June 7, 2022

Re: Nuevo Atrisco Tract B
7901 Central Avenue NW
Conceptual Traffic Circulation Layout for DRB Approval
Engineer's/Architect's Stamp 06-07-2022 (K10-D058)

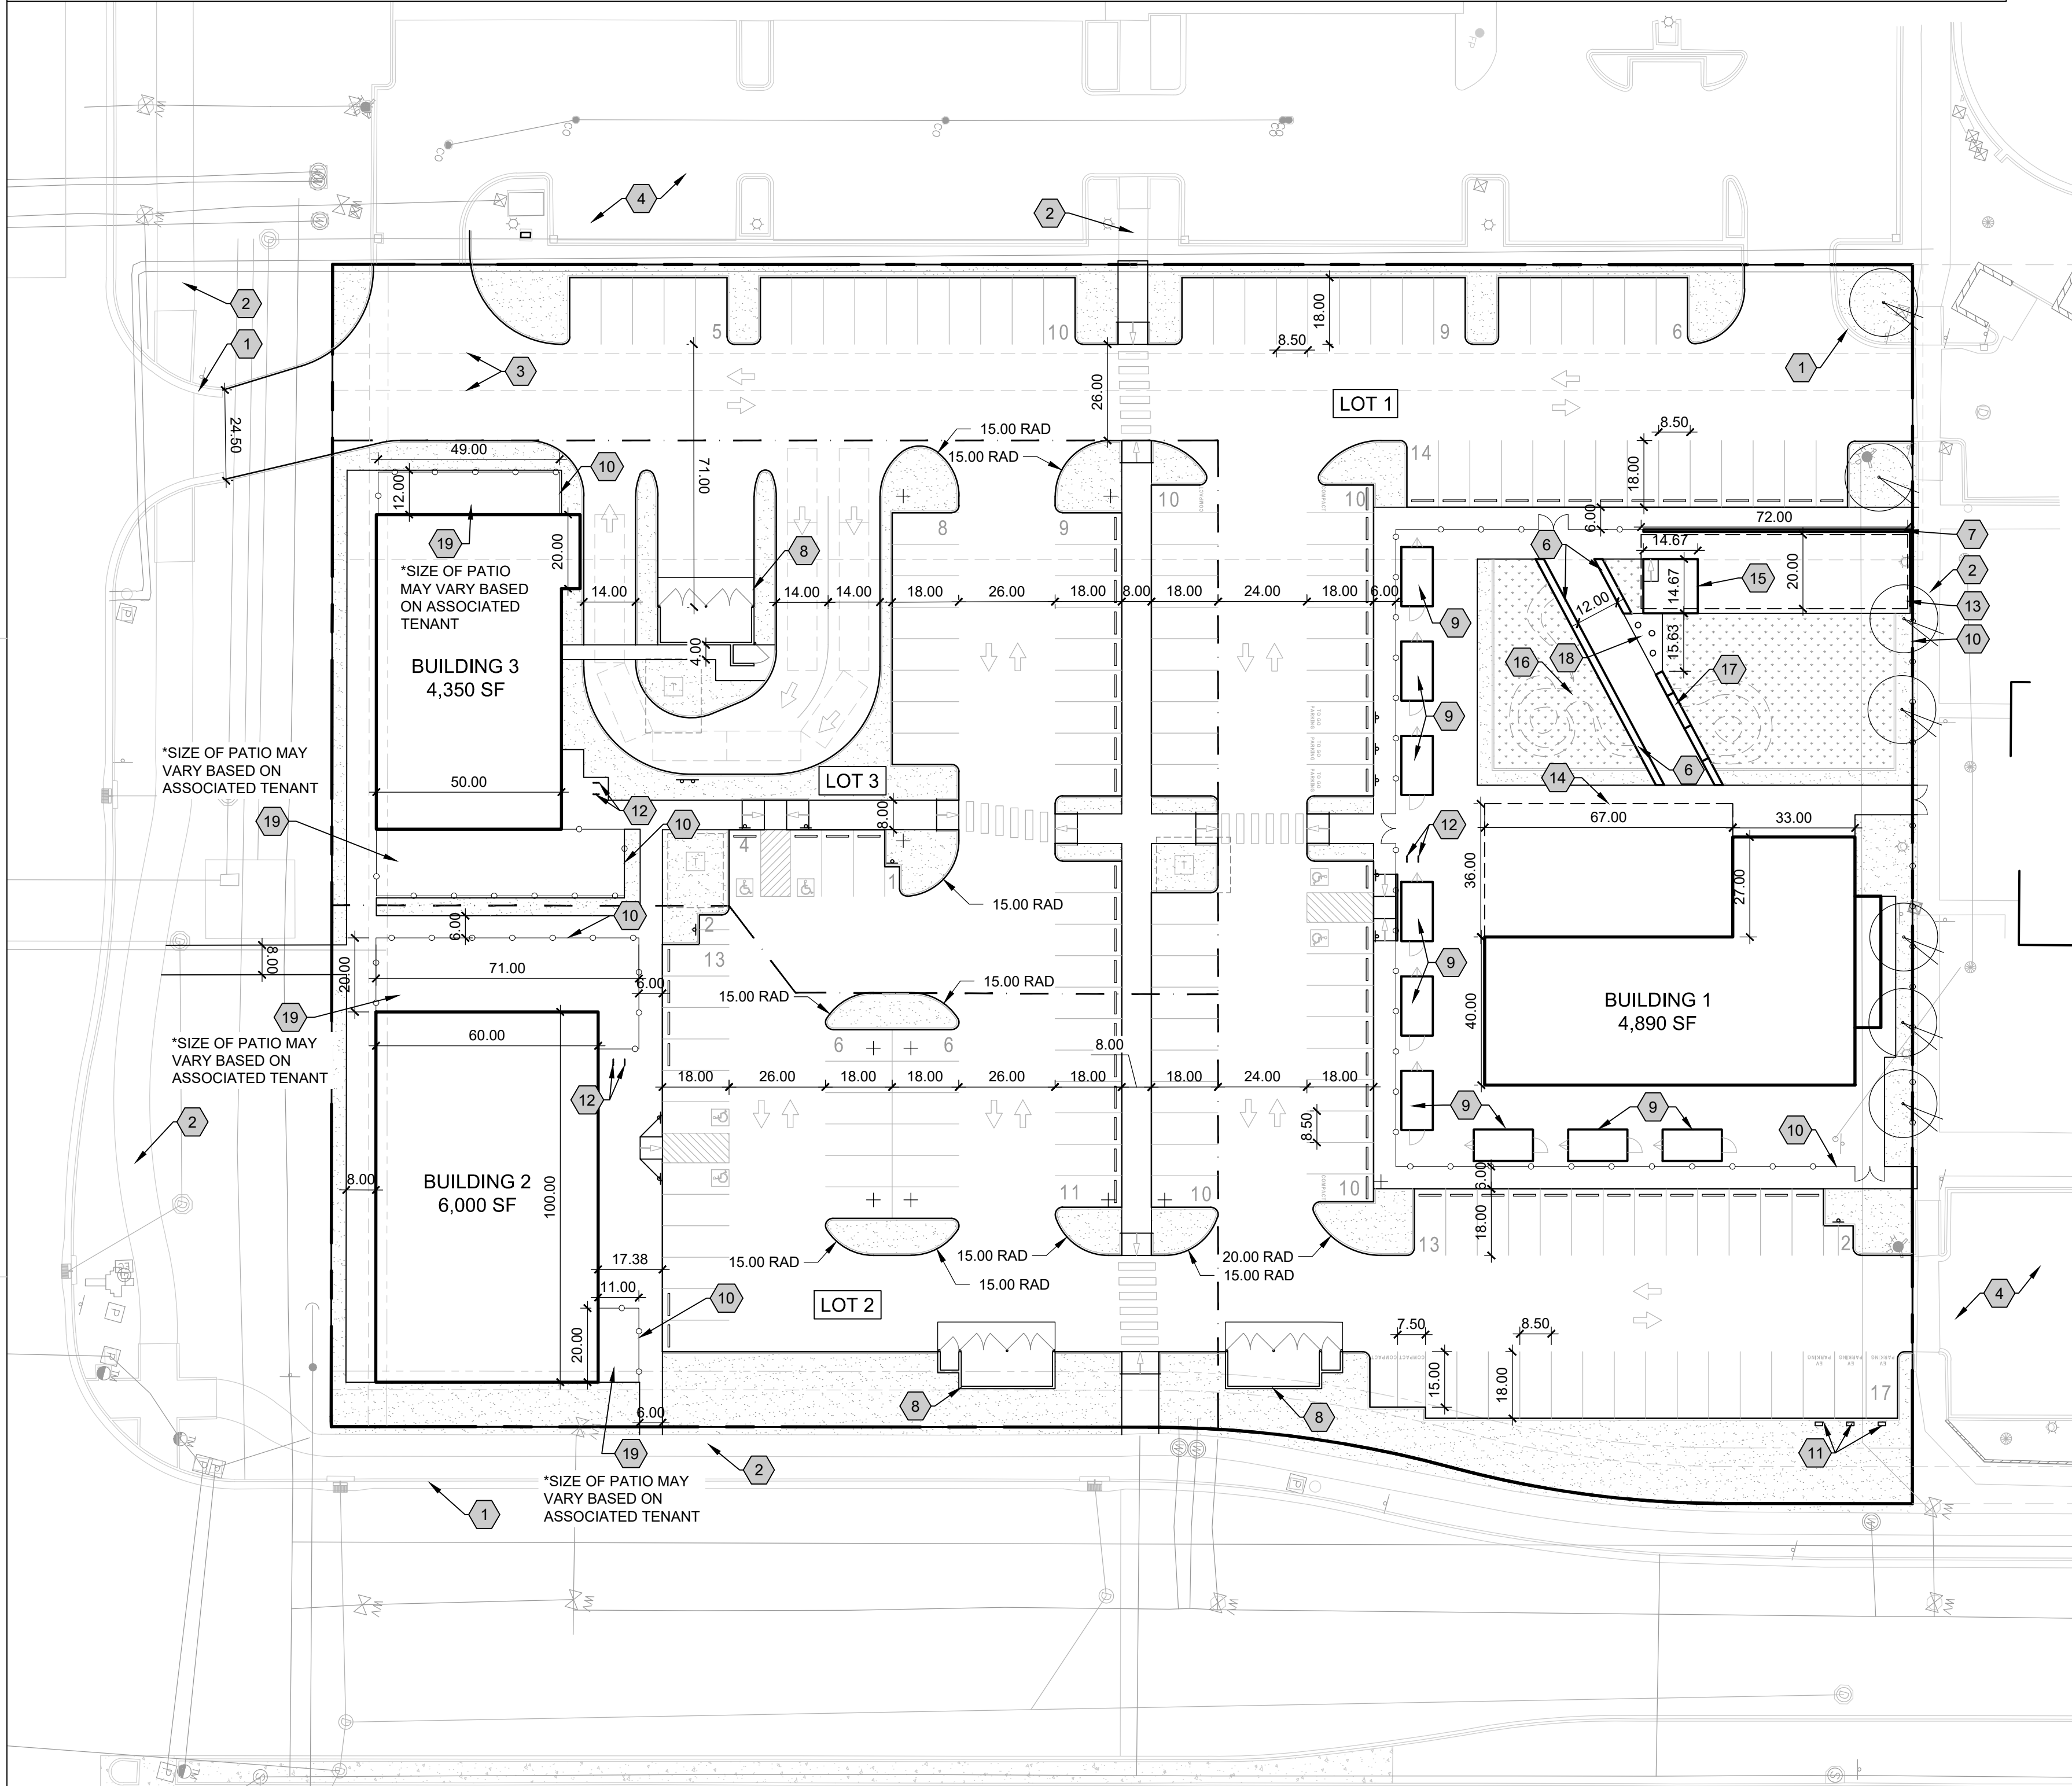
Prior to ultimate DRB approval for Site Plan, please provide a shared access agreement with the adjacent property and an application for a waiver to the required 10-foot wide sidewalk width along Unser Boulevard as a separate DRB application.
